TR040011: Portishead Branch Line – MetroWest Phase 1 Updates - ExA Issue Specific Hearings, 11 and 12th January 2021

A Submission on behalf of Ham Green St Katherine's Park and Chapel Pill Lane Residents concerning the Bio-diversity Impacts on the Ham Green fishing lakes of the Pill Tunnel Construction and Maintenance Compound

Figure 6 - Ham Green Construction
Compound
APFP Regulation 5(2)(a)

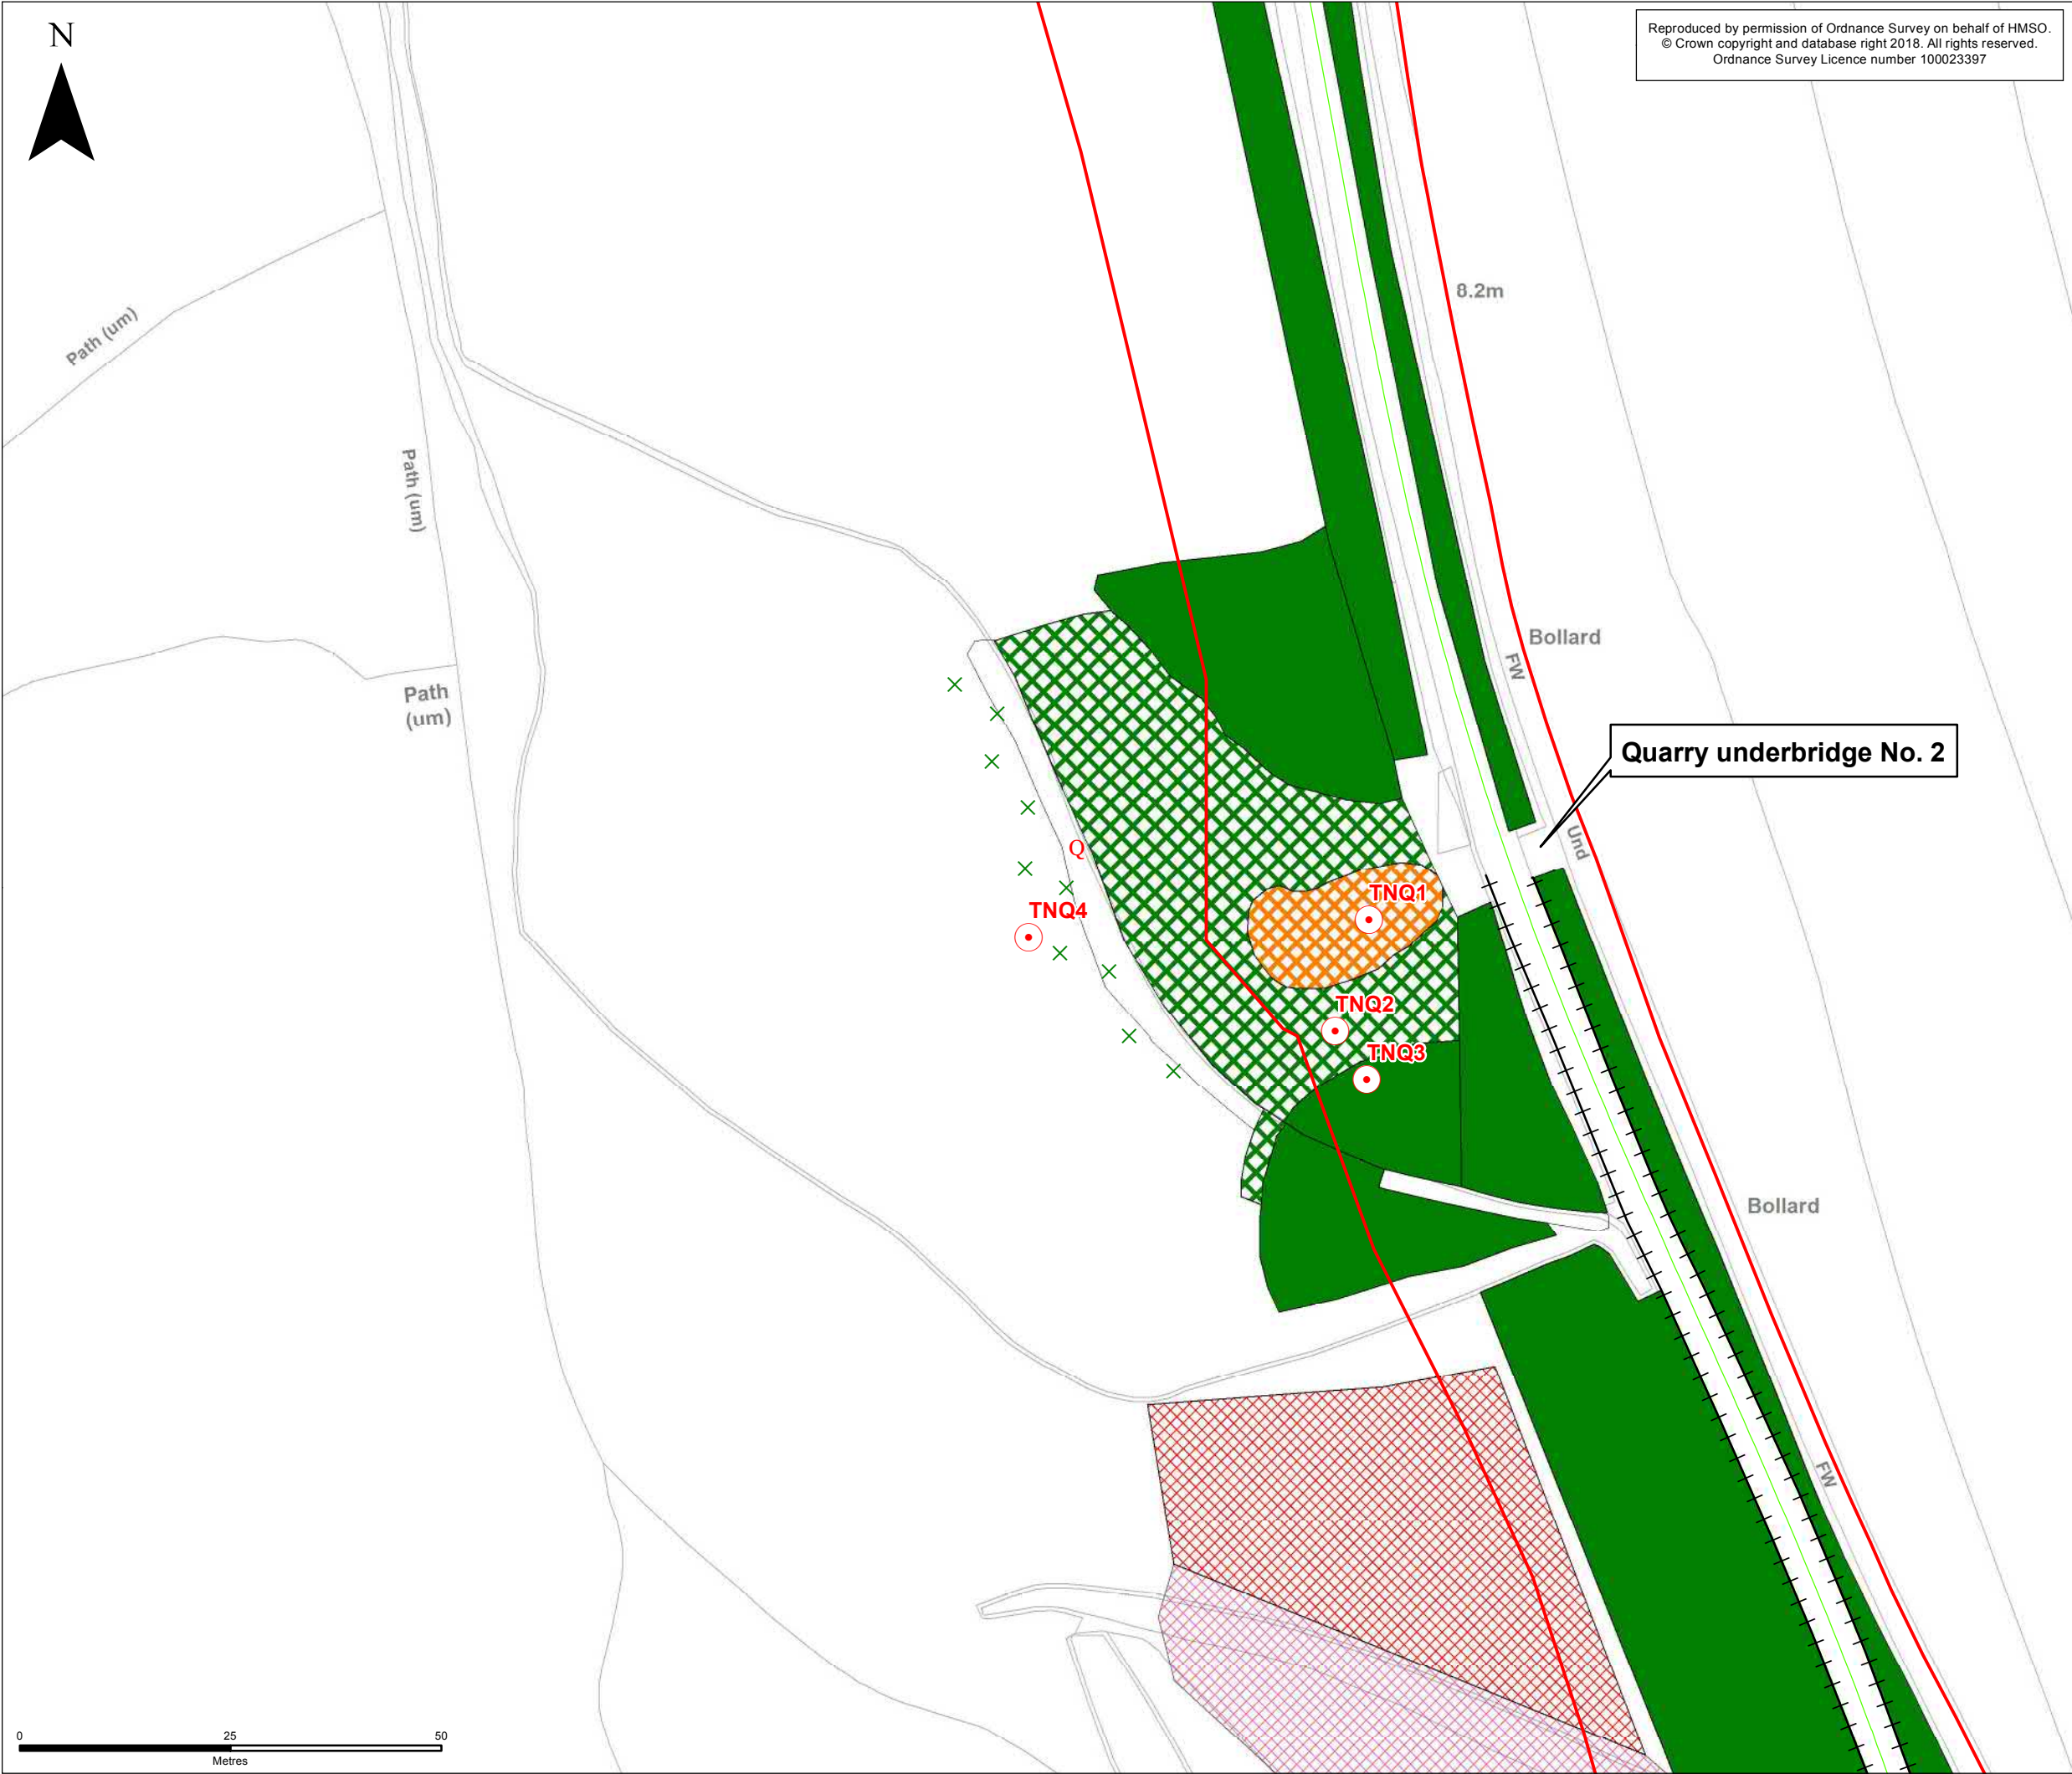
However, during their survey at the Ham Green Compound 26/05/2016 listed in figure 7, target note **HG4** states that an adult Grass Snake was found under a wooden panel; this does not appear to have been covered in the report?

***HG13** Connecting ditch with areas of ponding may have potential for Great Crested Newts 25/05/16*

It is understood that Toads and Great Crested Newts are present, not just likely, the presence of which in the pond are routinely monitored by a St Katherine's School caretaker who has a newt licence to survey them.

4.5.61 Otters are known to be present within the vicinity of Ham Green Construction compound and a spraint was located next to the railway bridge, during the Ham Green Survey of May 2016.

The lake owner has recently erected fences in the lower lake as a preventive measure against otter attack to the fish. Large (5lbs or more) half-eaten fish (Bream etc) have been found abandoned very close to the lake that on further investigation have provided clear evidence of otter attack.

Target notes **HG6, HG7, HG12** (p156-p158) 2 mature Oaks with Bat Potential, 1 Mature Oak with High Bat Potential.

It is understood that this is the oak tree (TPO No.857 dated 2nd July 2004) that the affordable for social rent housing development of 12-16 dwellings proposed in the draft Abbots Leigh, Ham Green, Pill and Easton in Gordano Neighbourhood Plan will, if built, effectively enclose. Can confirmation of this be provided and of the measures that will be taken to prevent shared access so that the development cannot proceed to threaten this sensitive site (see also the Applicant's response to Representations at the Open Floor Hearing Held on 19 October 2020).
